Re Submission to exhibition of SSD-82709458 at 19-25 Balfour Street, Lindfield

We write on behalf of the owners of Nos 8 to 14 Highfield Road, Lindfield (“**our clients’ property**”) in relation SSD-82709458 at 19-25 Balfour Street Lindfield (“the development site”). Our clients’ property adjoins the site to the north and shares a common rear boundary with the development site. The relationship between our clients’ property and the development site is shown in the following diagram.

1 **OVERSHADOWING - 11AM JUNE 21 (EXISTING)**
1 : 1000

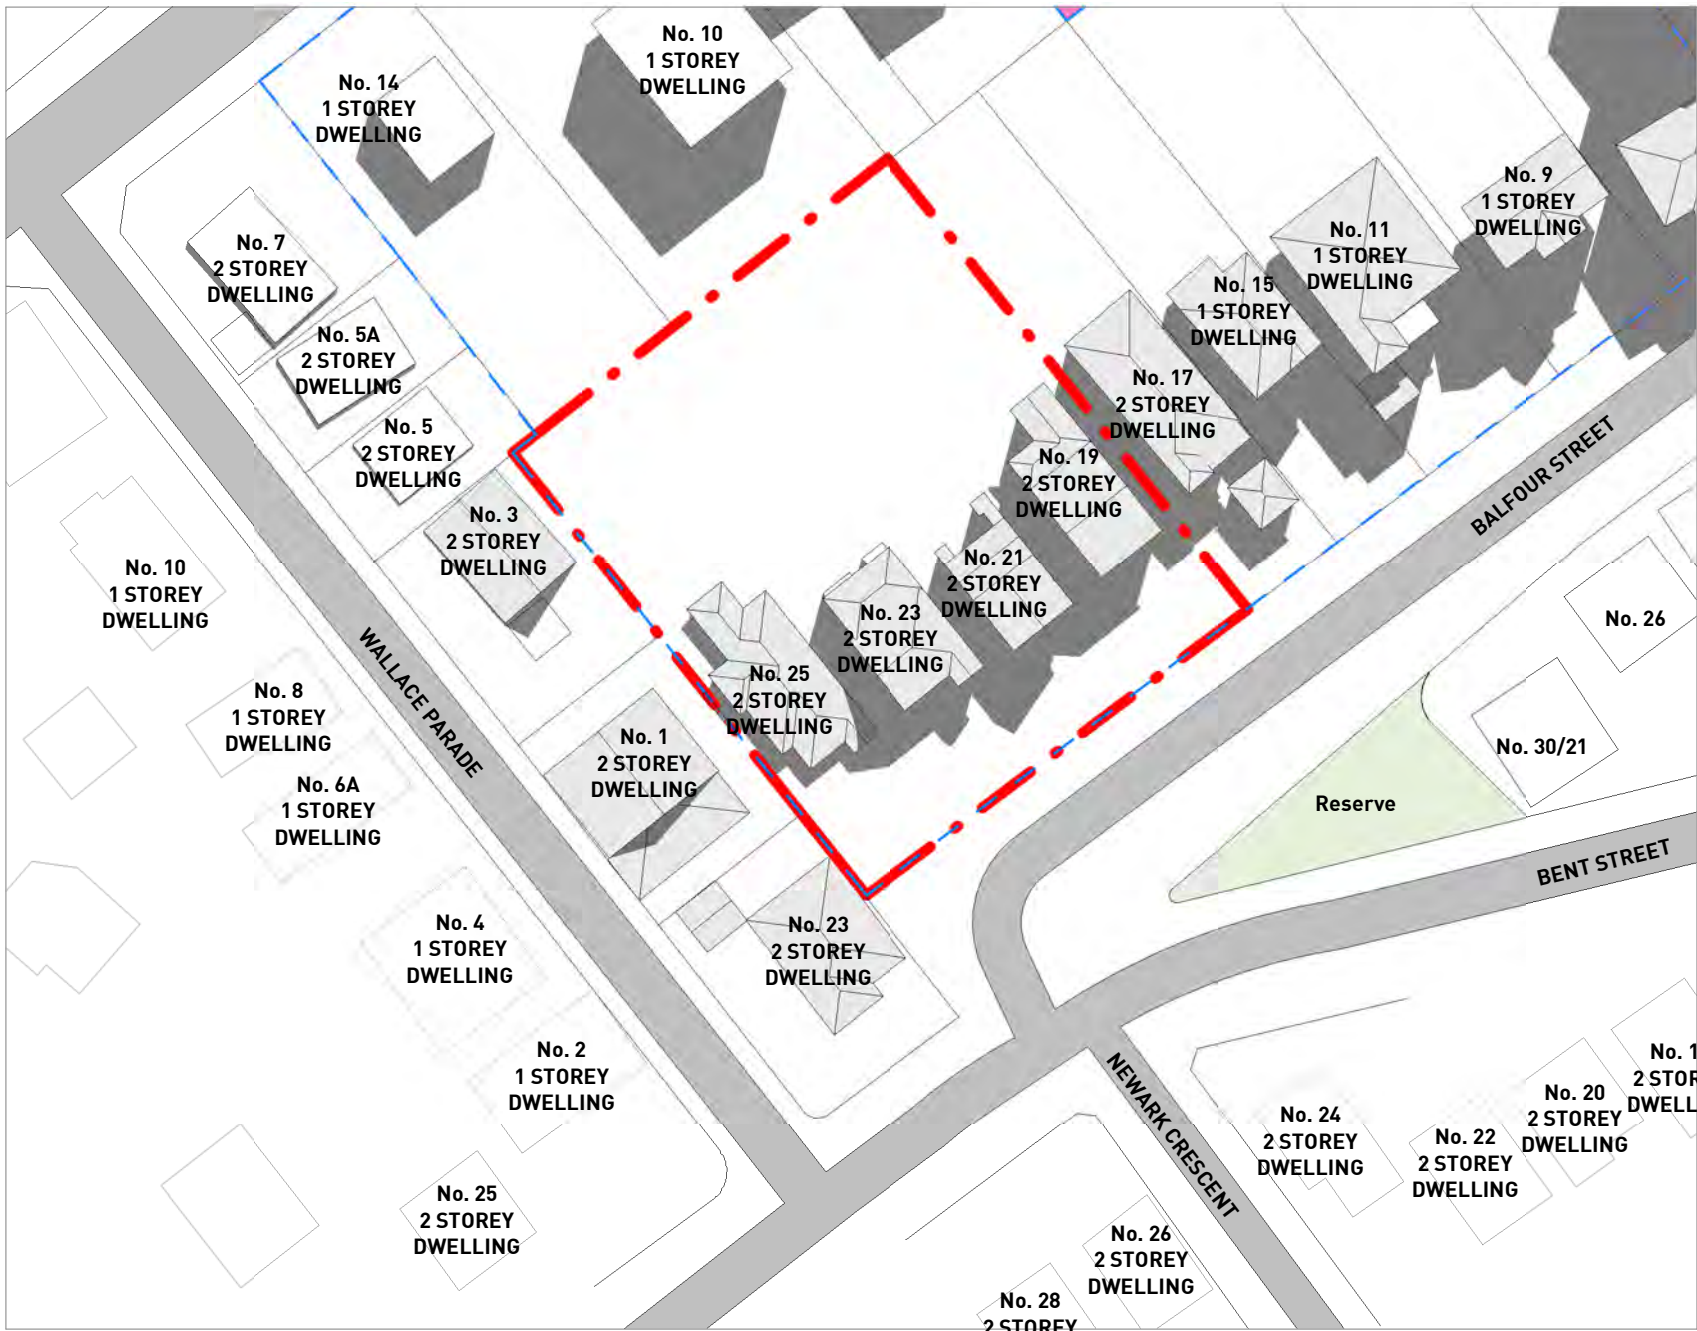
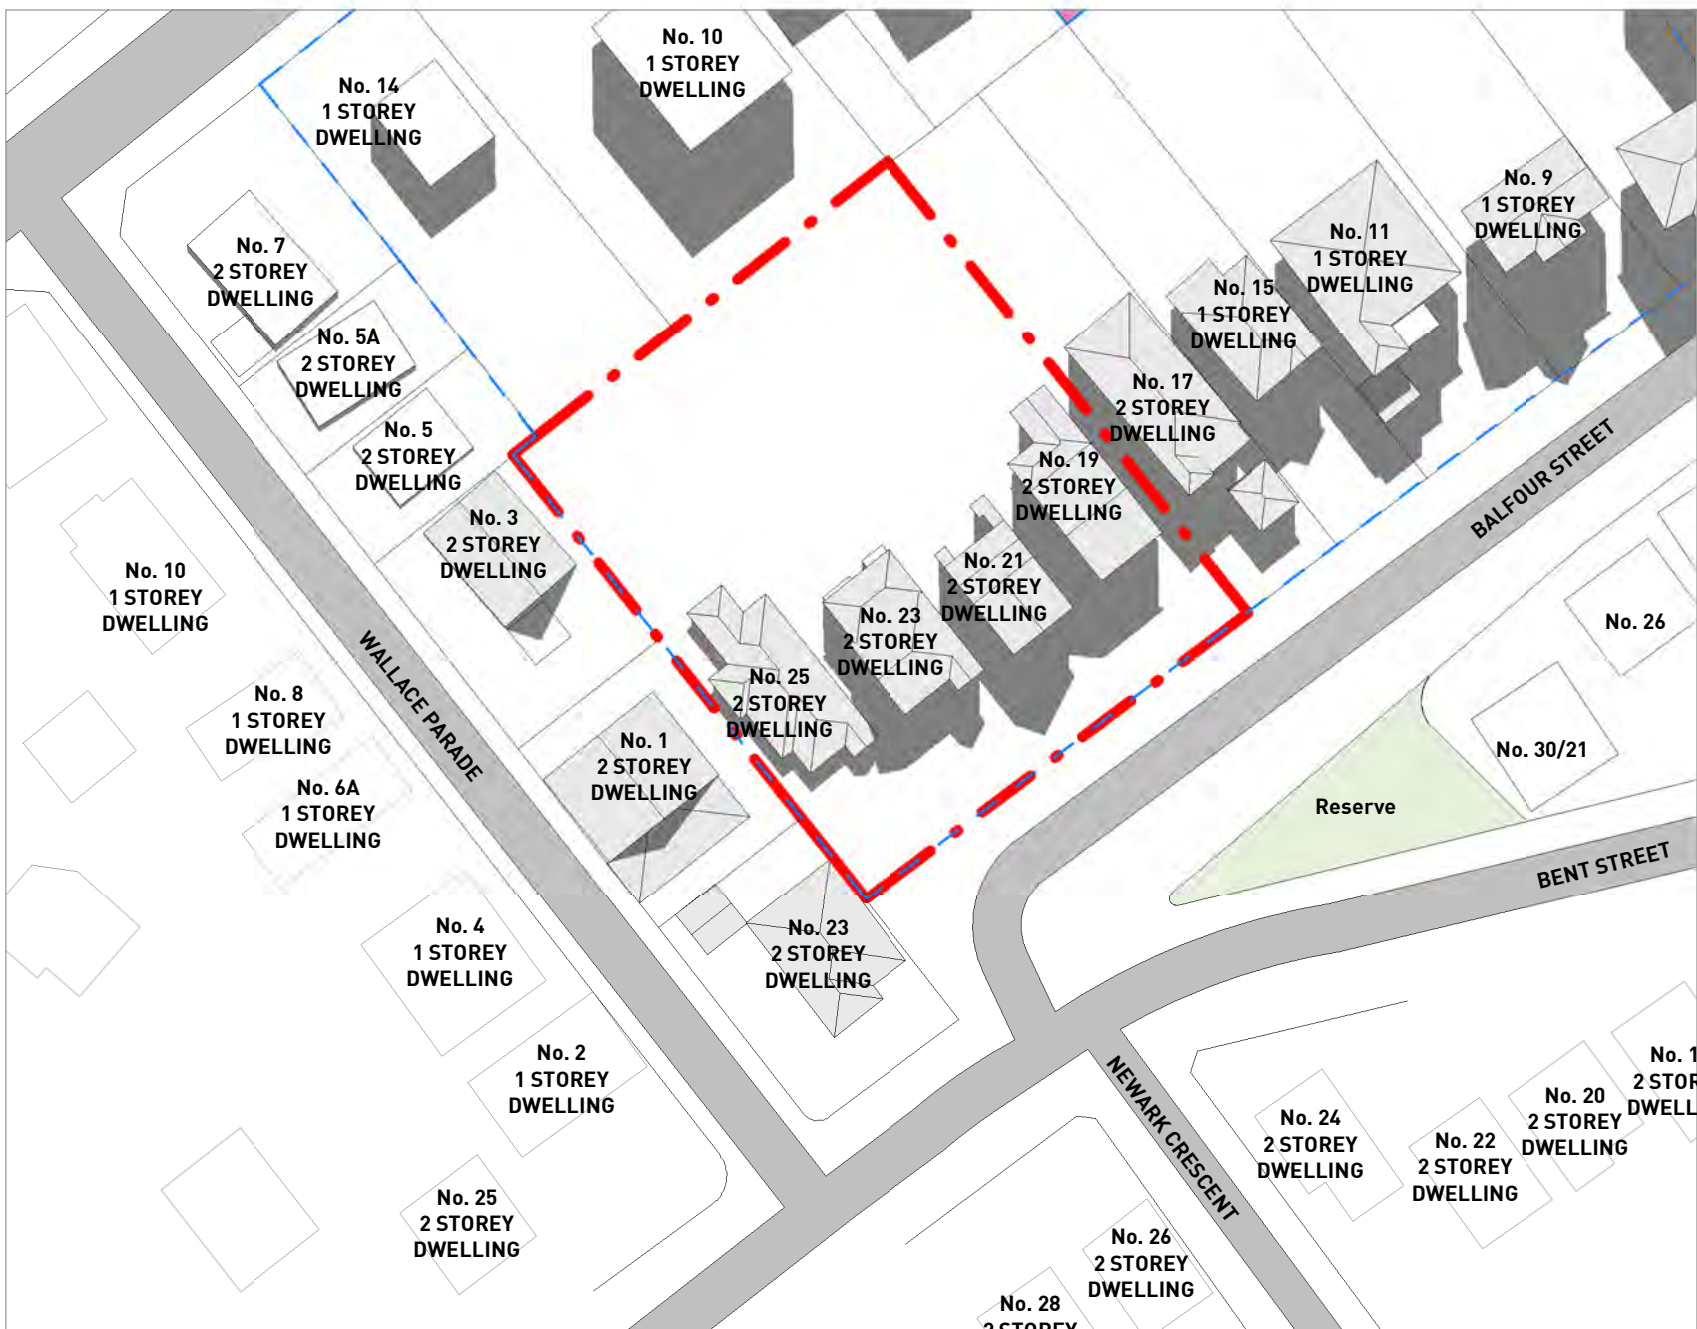
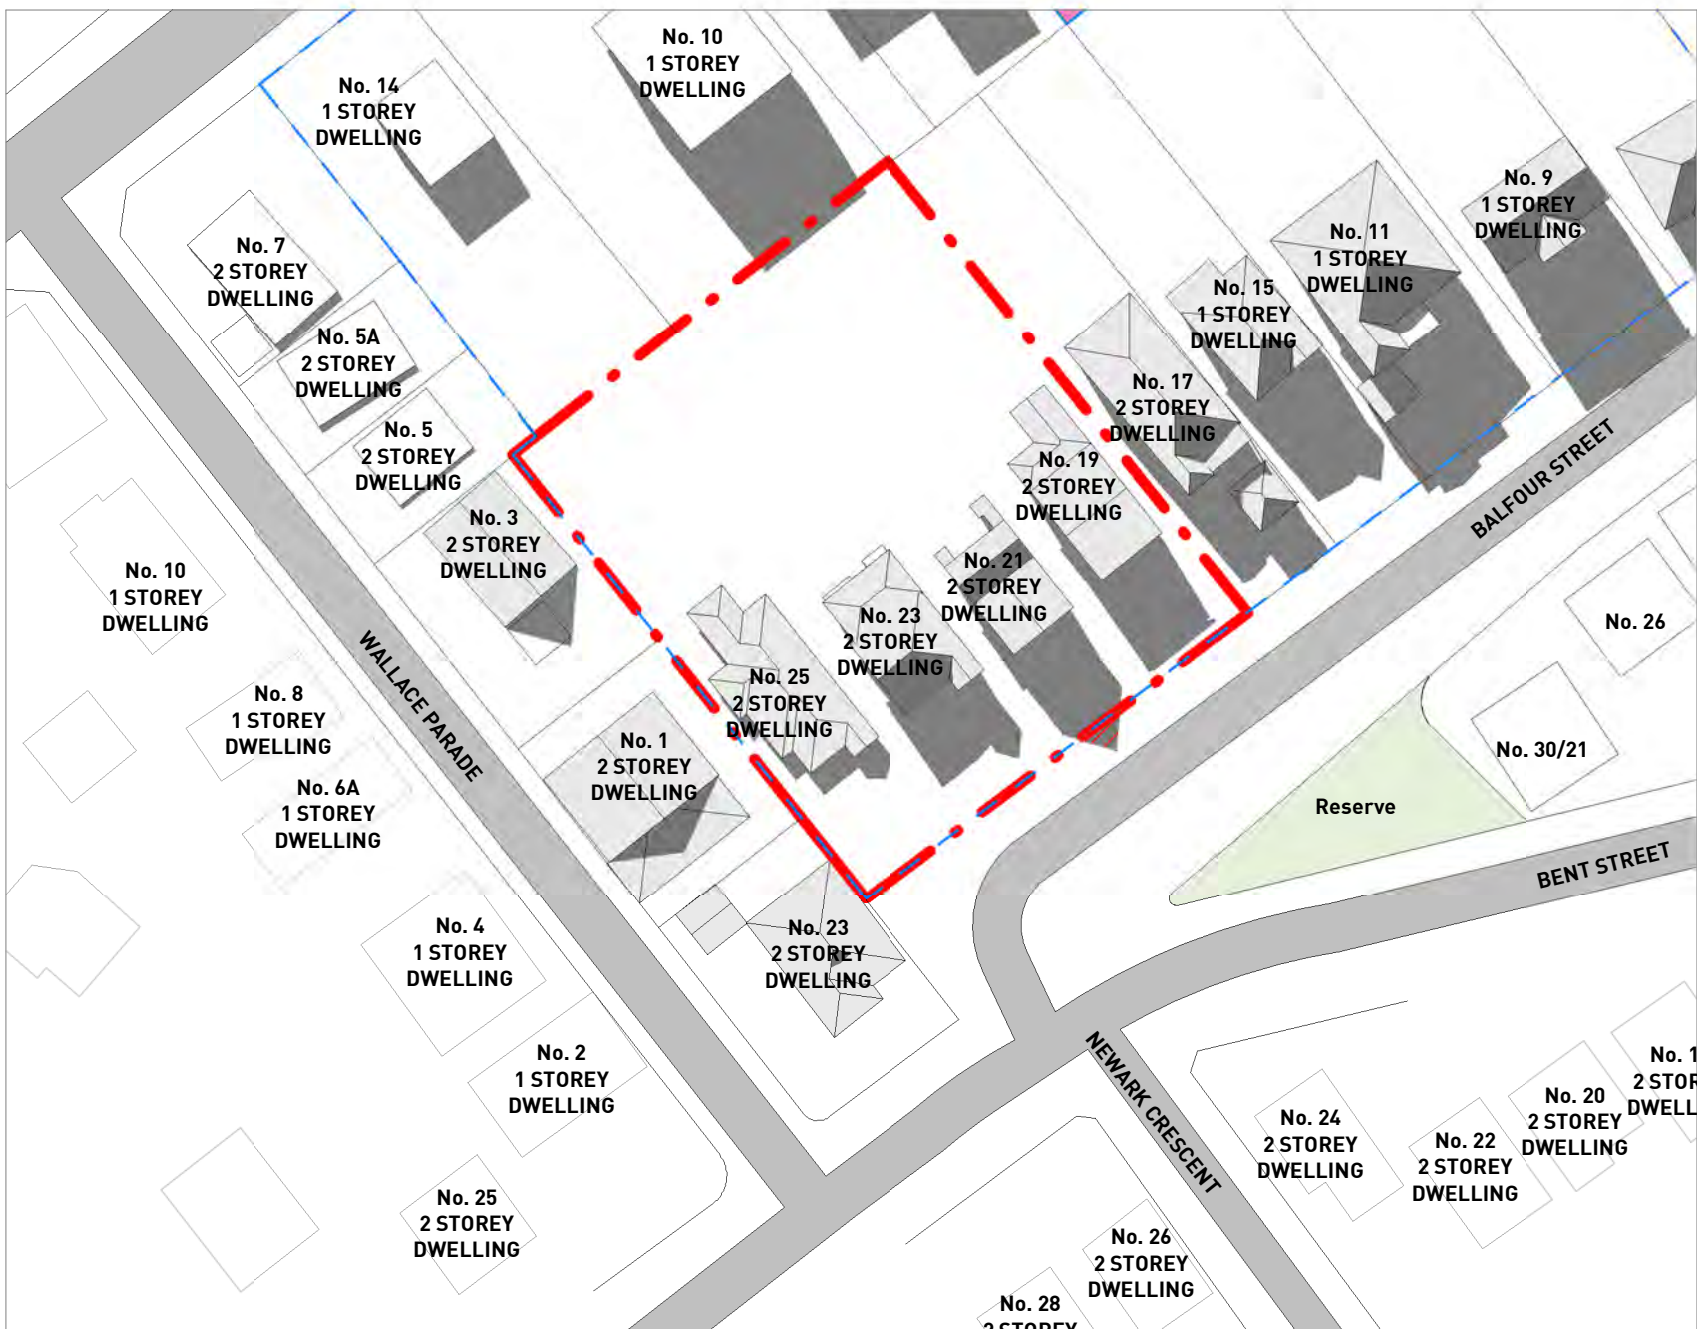
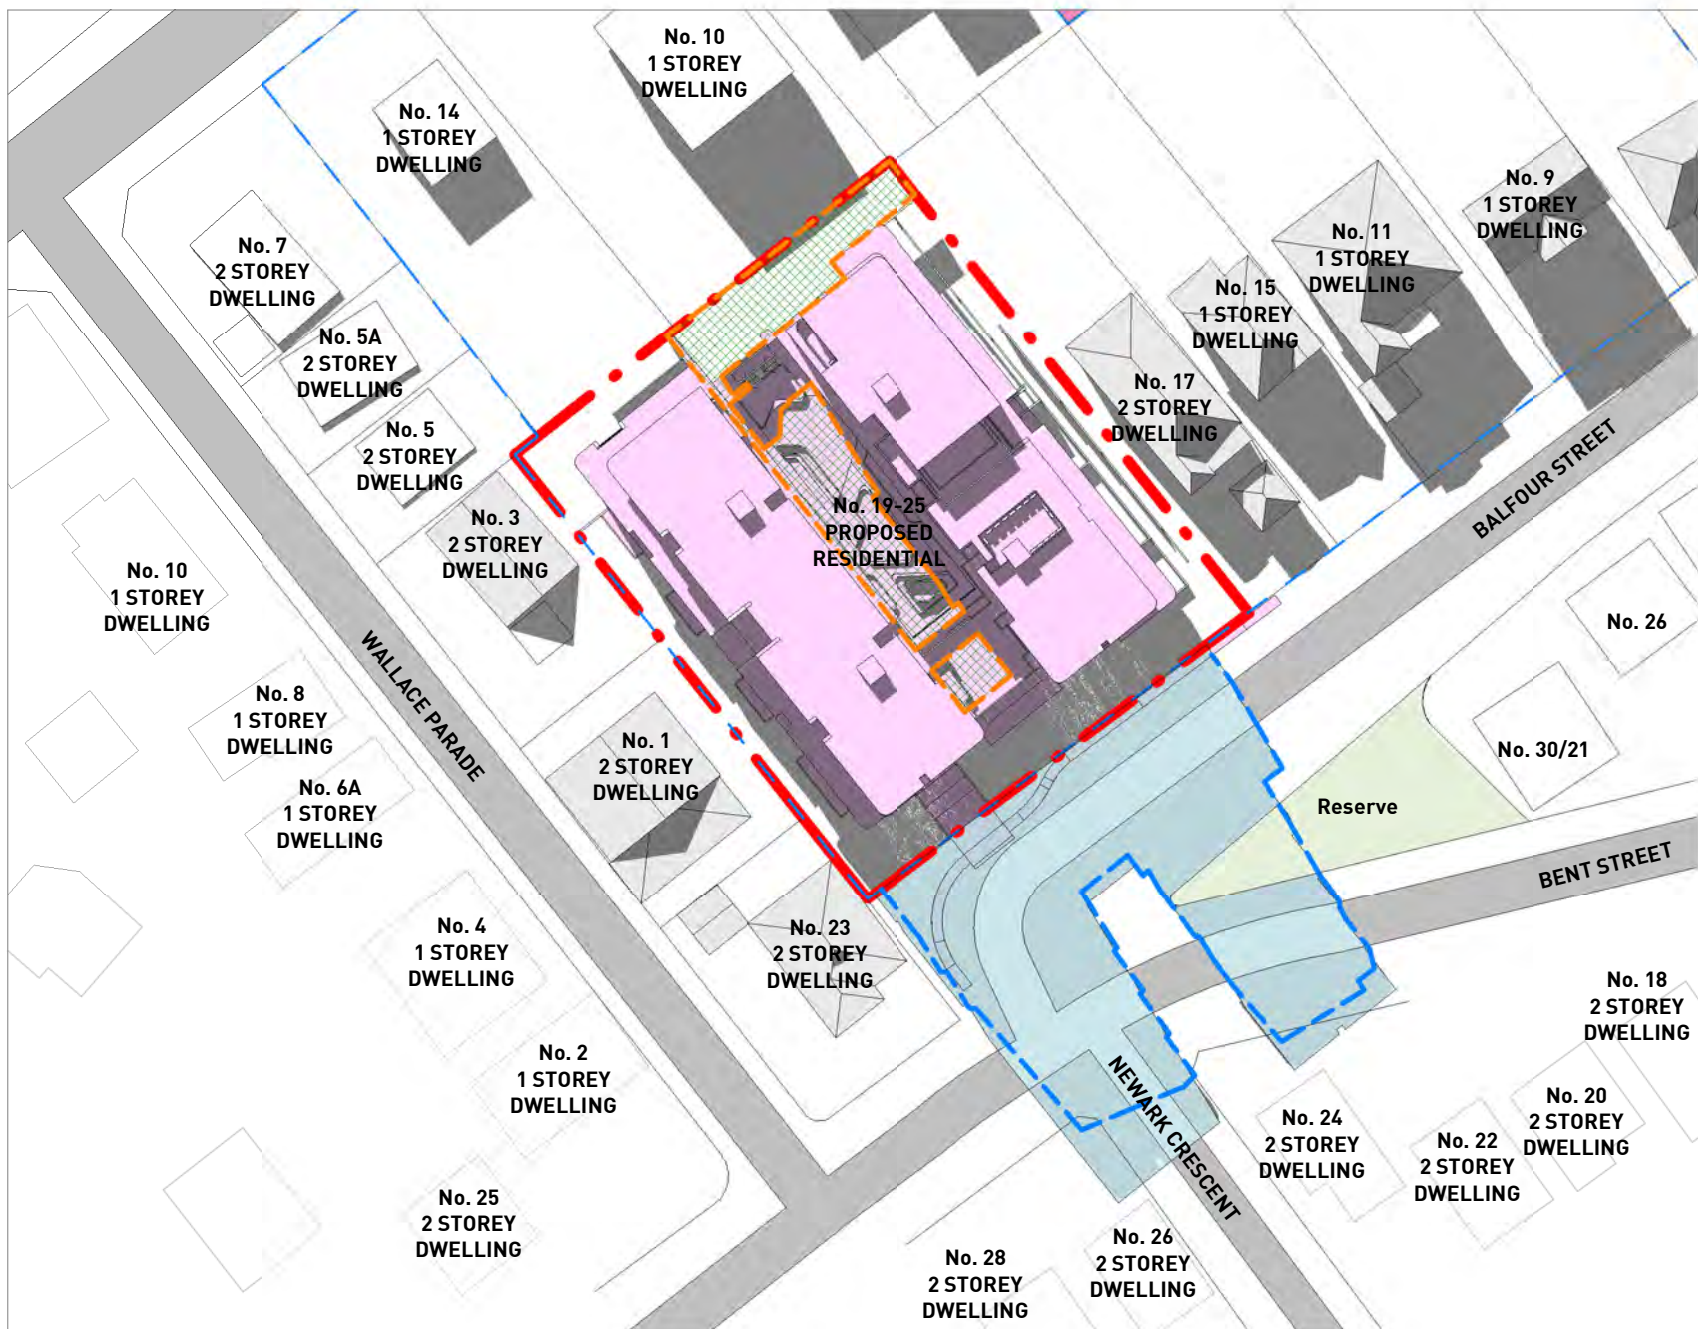
The shadow diagrams show that the proposed development will result in the loss of solar access at mid-winter to the rear yards of the adjoining three residential properties to the south

west from before 9.00am to 1.00pm. Councils preferred TOD alternative scheme indicated that these three properties have an FSR of 1.8:1. The narrow depth of these properties and the level of overshadowing will result in a significant reduction in amenity for these dwellings with the shadow not avoiding these properties until 2.00pm. This overshadowing is made worse by the non-compliant building height and the non-compliant building setbacks.
